CITY OF ALBUQUERQUE

January 15, 2016

**Re: Santuario De San Martin De Porres Church
8301 Camino San Martin SW
Request for Permanent C.O. - Accepted
Engineer's Stamp dated: 10-29-14 (M10D002)
Certification dated: 1-14-16**

GRADING AND DRAINAGE PLAN

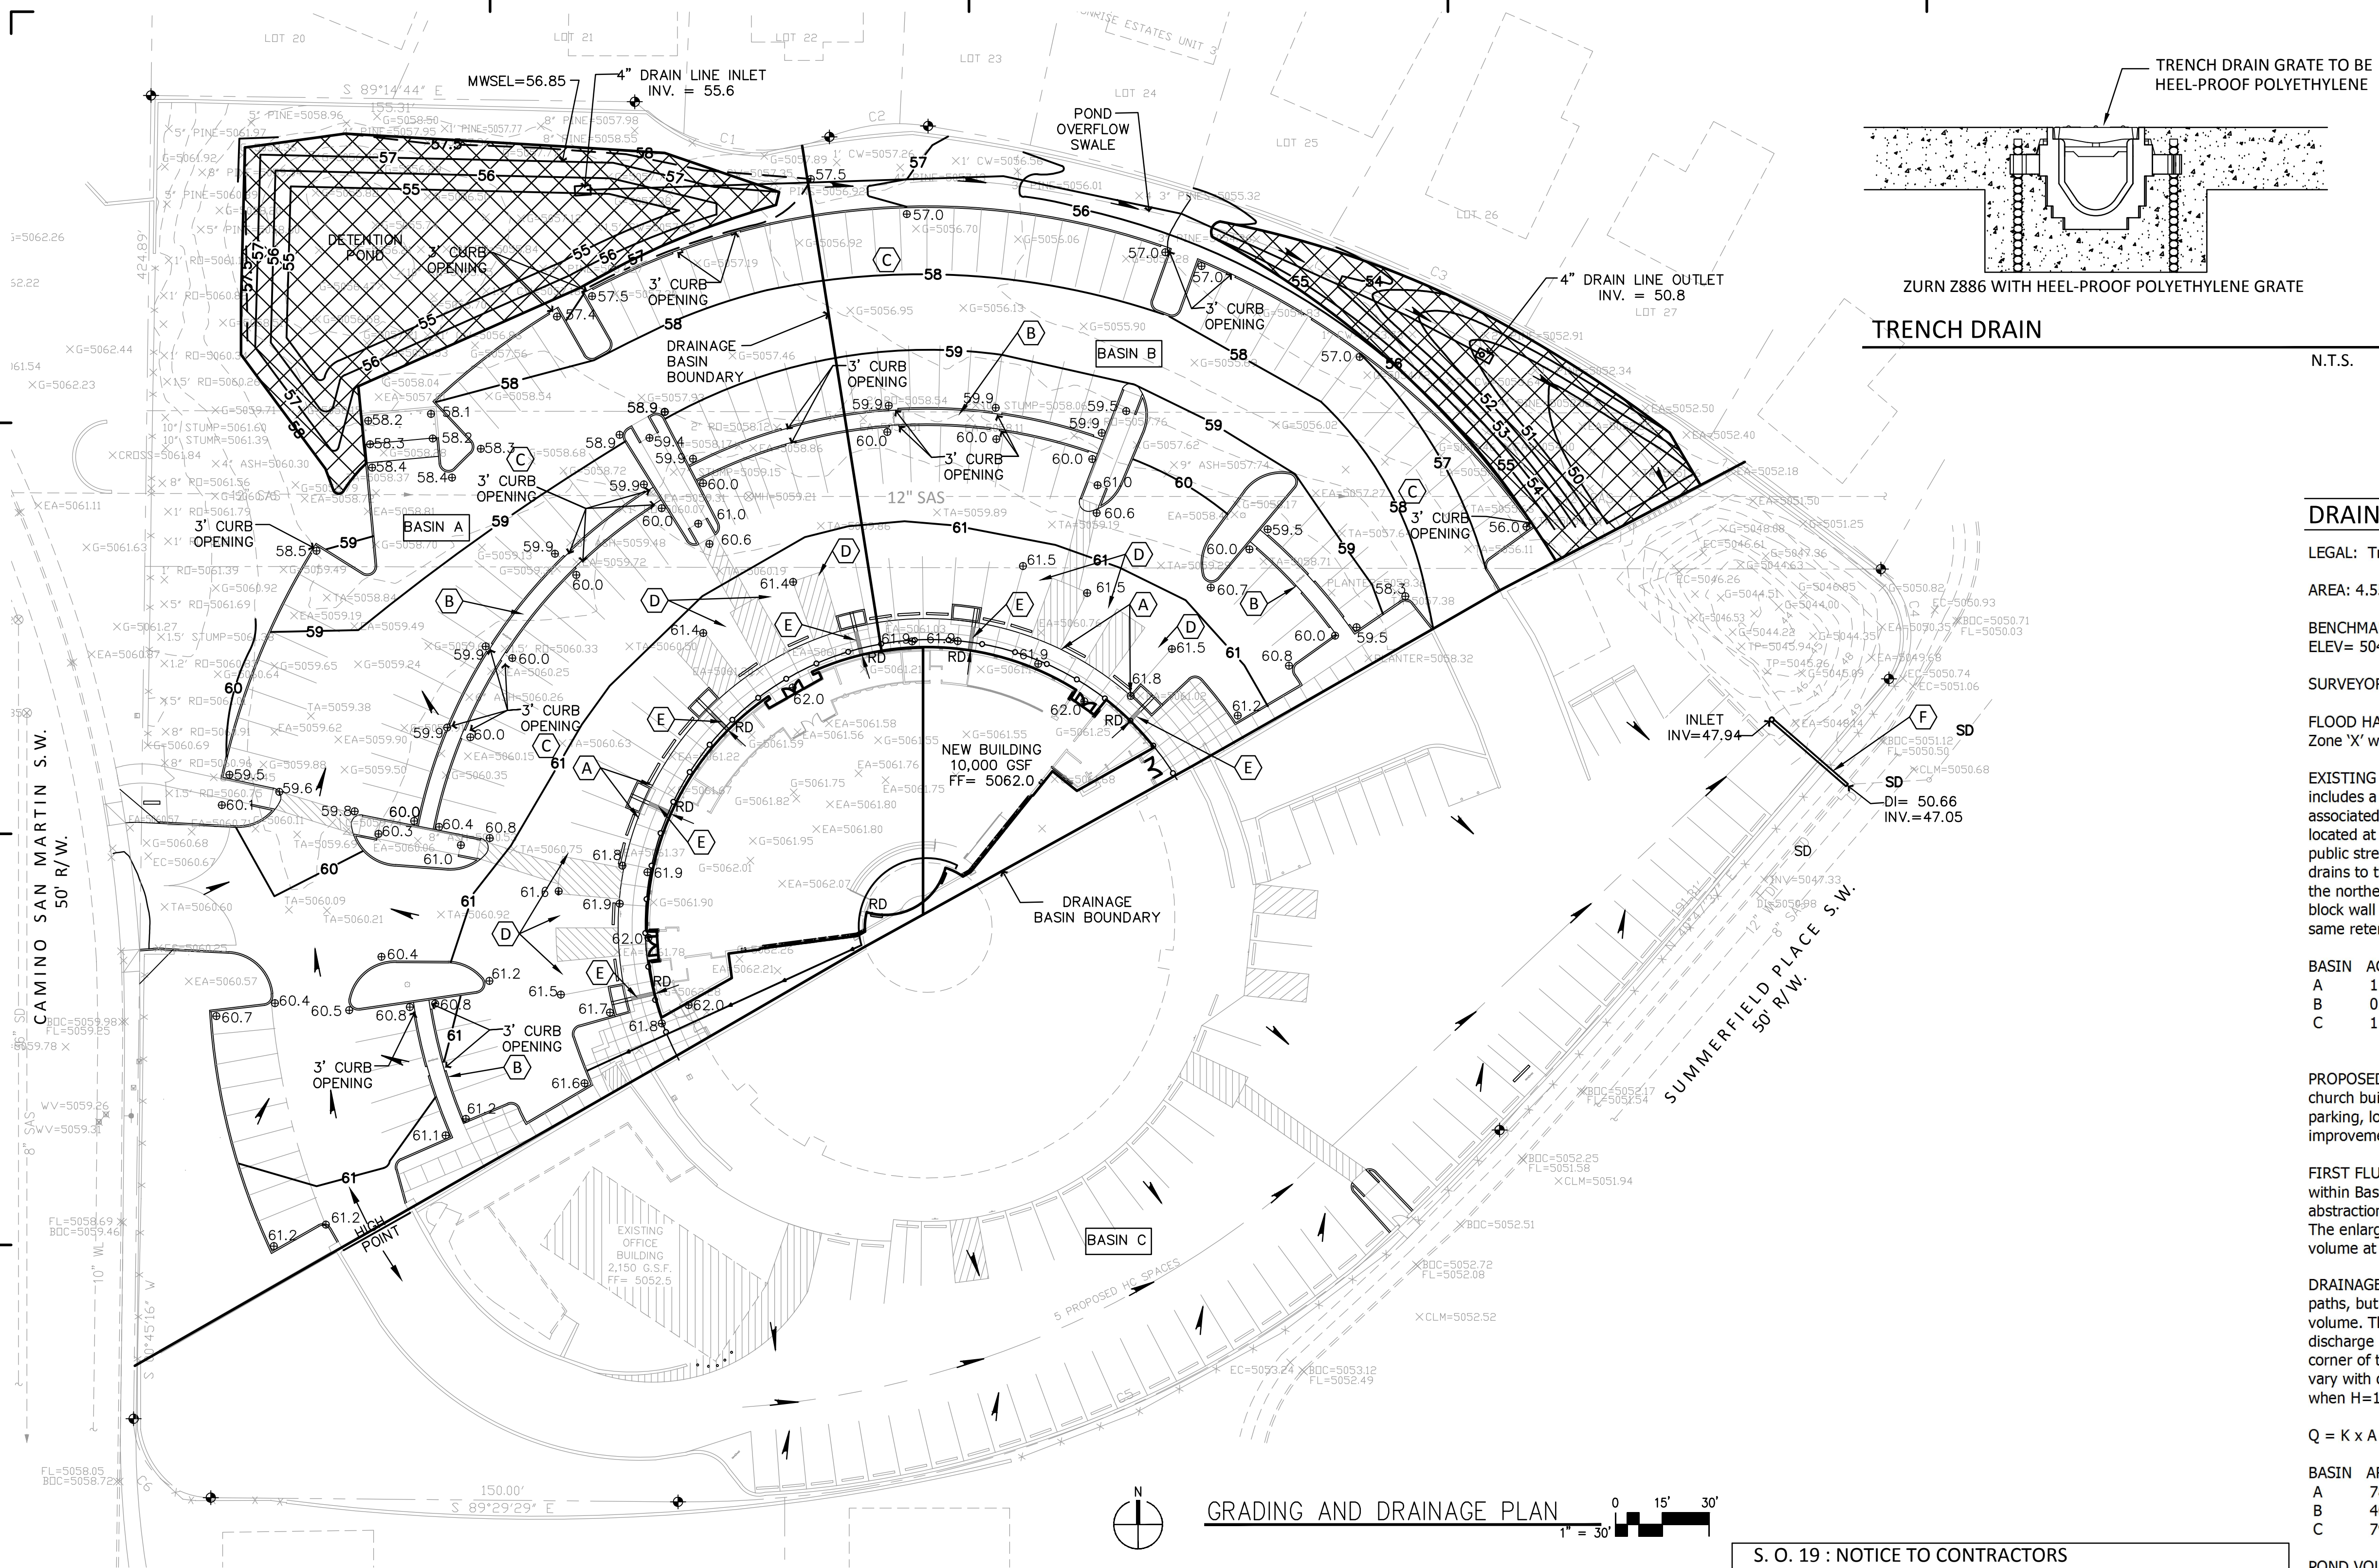
I was at the site today for the hydrology CO. The drawing calls out for 3' curb openings. Most of the openings are approximately 17". Please see attached pics of a couple of them. Would you please confirm that this will have no impact on the drainage of the site? Thank you.

I noticed the narrower curb openings also when I visited the site. With the multiple number of curb openings designed and constructed the narrower (17") width will not be a problem.
